October 3, 2024

RE: 845 Juan Tabo NE
Grading and Drainage Plan
Hydrology File: K21D019

Based upon the information provided in your submittal received 09/27/2024, the Grading and Drainage plan is **not approved** for Building Permit / Grading Permit. The following comments need to be addressed for the approval of the above referenced project.

845 JUAN TABO BLVD., NE GRADING AND DRAINAGE PLAN

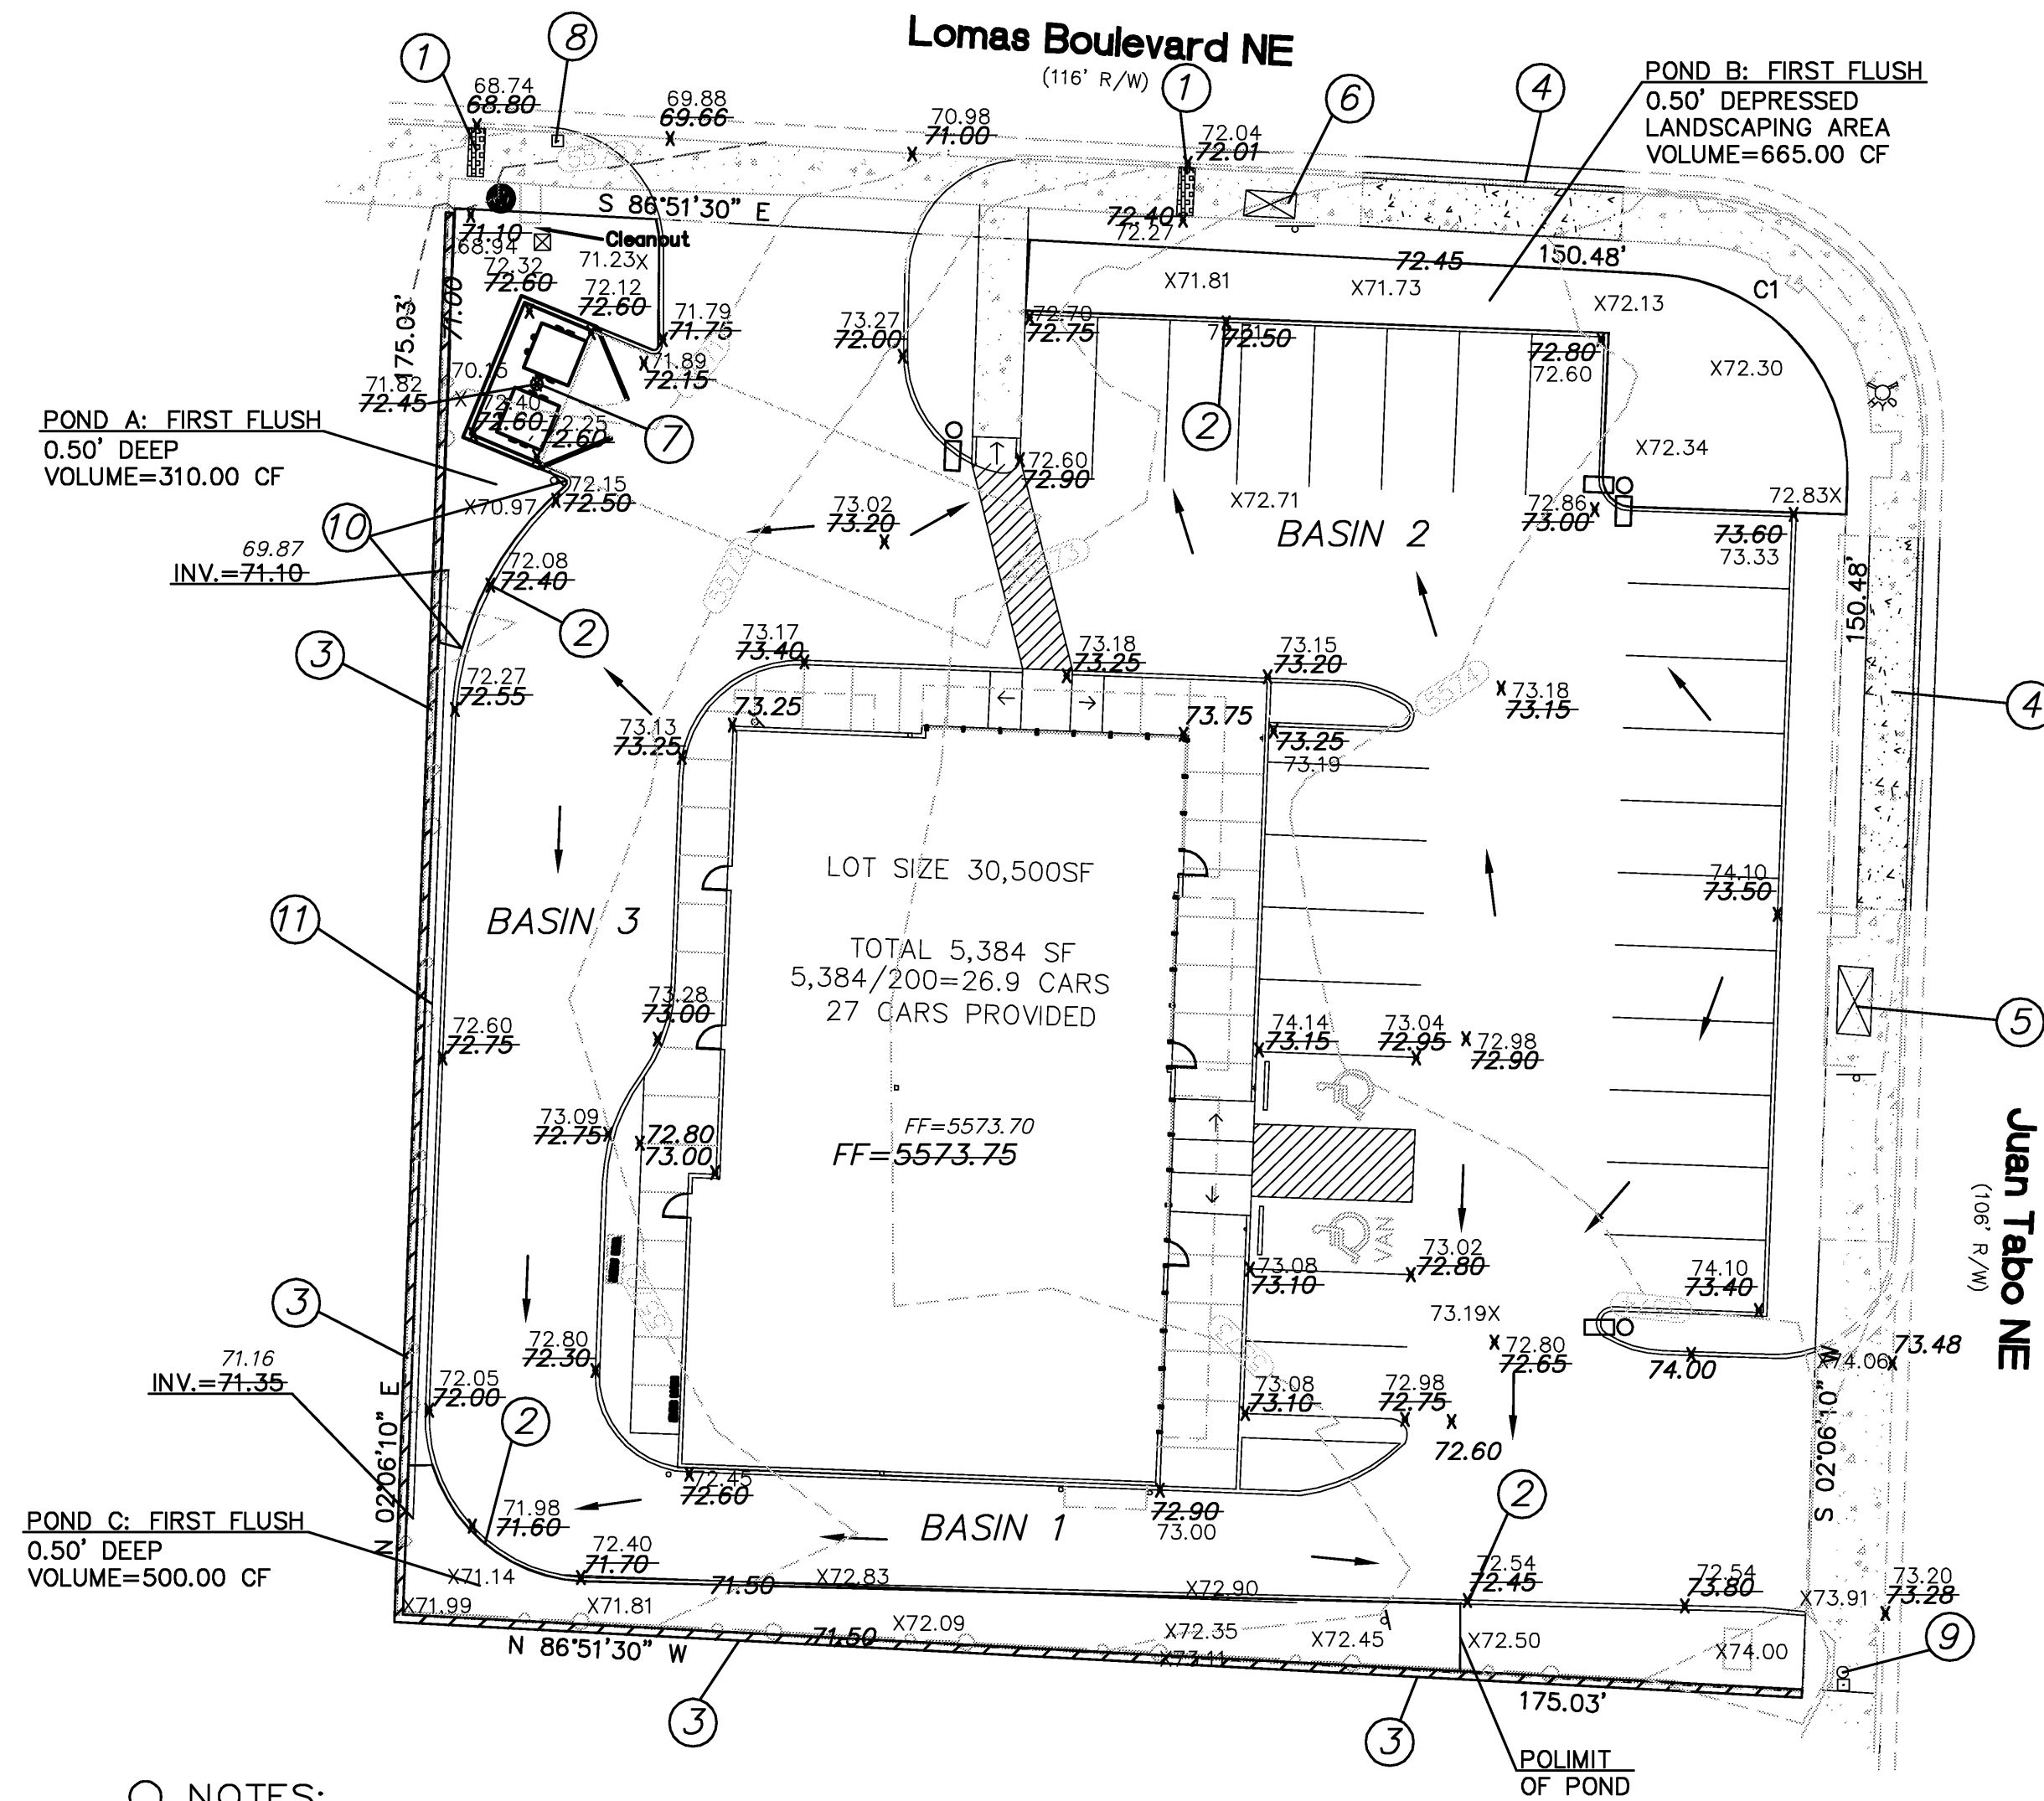
1. This site qualifies as redevelopment and is only required to retain runoff from the 80th percentile storm (Vol. = 0.26"*Imp.Area). To calculate the required SWQV, multiply the impervious area draining to the BMP by 0.26 inches for redevelopment sites.

2. Please show the Land Treatment (A, B, C, D) percentages for the existing and proposed development.
3. Please show the 100-yr 6-hr Weighted E, Volume, and Flow calculations for existing and Proposed development.

4. Please provide the SWQV calculations for each basin draining to each pond. The stormwater quality ponds need to be sized for the areas draining to them.

5. For trash enclosures serving food service developments, trash enclosures must demonstrate control of liquids from dumpster areas per DPM by containing runoff from the dumpster area, preventing outside drainage from entering the dumpster area, and discharging to the sanitary sewer. Per the DPM Section 6-12(D)(2), a berm around the pad may be required to ensure that stormwater runoff from the site will not mix with stormwater falling on the trash enclosure pad. Please show a berm or other means to prevent storm water from entering the dumpster area.

6. Pond Calculation Section – Pond C is not shown. Pond B is shown twice. The calculation is different for the middle Pond B Volume. 55000 cf for the middle Pond B does not match the other references. Total Pond Volume does not match the other calculated values. Please check these calculations and verify that they are matching the other volumes in the plan.

7. There is a conflict with Pond C and the existing transformer at the SE corner of the site. Please adjust Pond C to exclude the transformer from that area.
